Your ref: 3/2017/0968 and 0969

Date: 20th November 2017

Planning Applications 3/2017/0968 and 0969: Demolition of redundant farm building and conversion of farm building adjoining existing offices to create additional office space. Construction of car park with landscaping works, new sewage treatment plant and soakaway; Redundant farm building and land at the rear of Richard Turner and Son Ltd, Old Sawley Grange, Gisburn Road, Sawley BB7 4LQ

5417 - 3

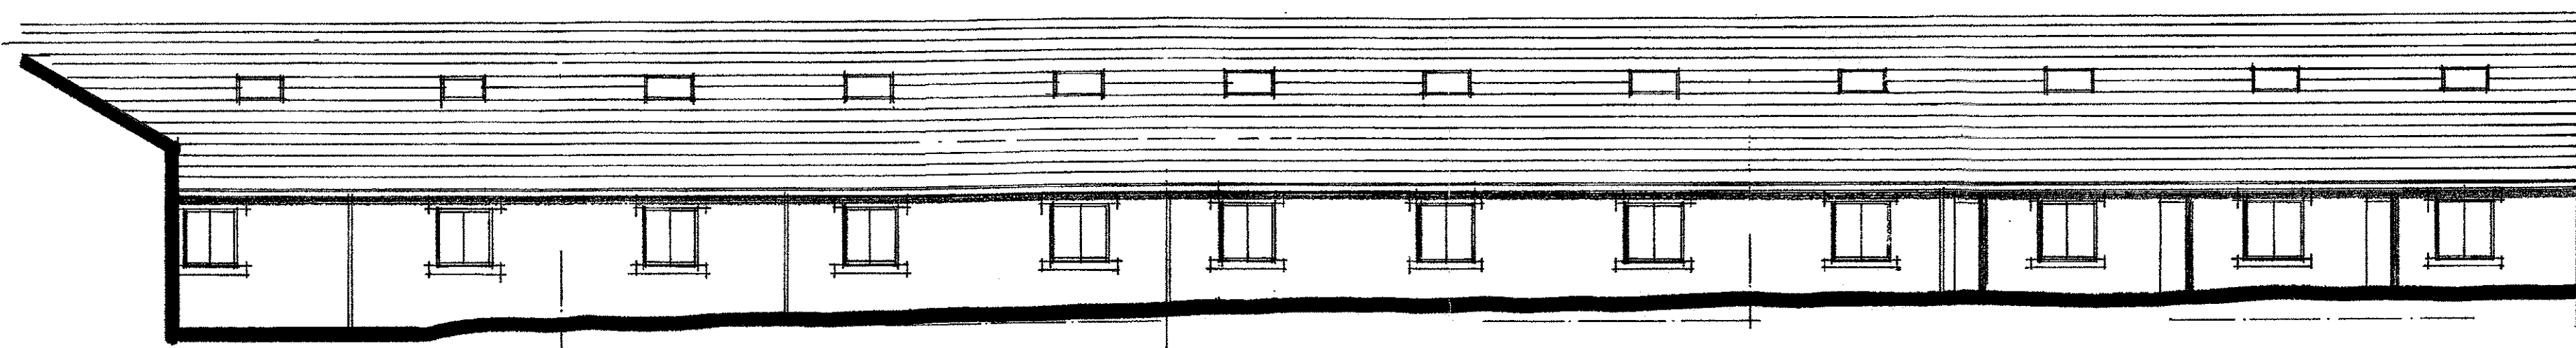
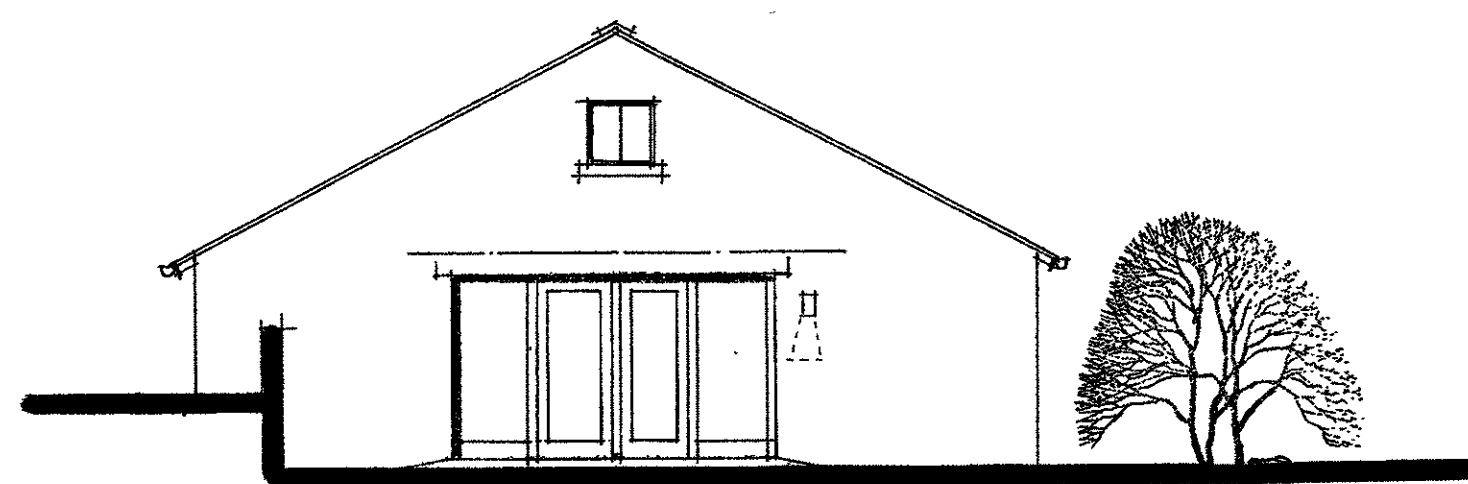
Section 7.4 of the DAHS states that '*The external appearance of the building is to remain relatively unchanged ...*' yet comparison of the elevations as existing and as proposed (ref. 5417-3, dated Aug 2017) show twelve windows and skylights on the east elevation and eight windows, four doors and twelve skylights on the west elevation, replacing five windows and a section of translucent ridge on either elevation in the existing structure. The plan as proposed (ref. 5417-2, dated August 2002) and the elevations as proposed also show a porch structure built into the junction of the extant offices and the building to be converted, but no details of this are provided nor of its impact on the extant buildings' structures.
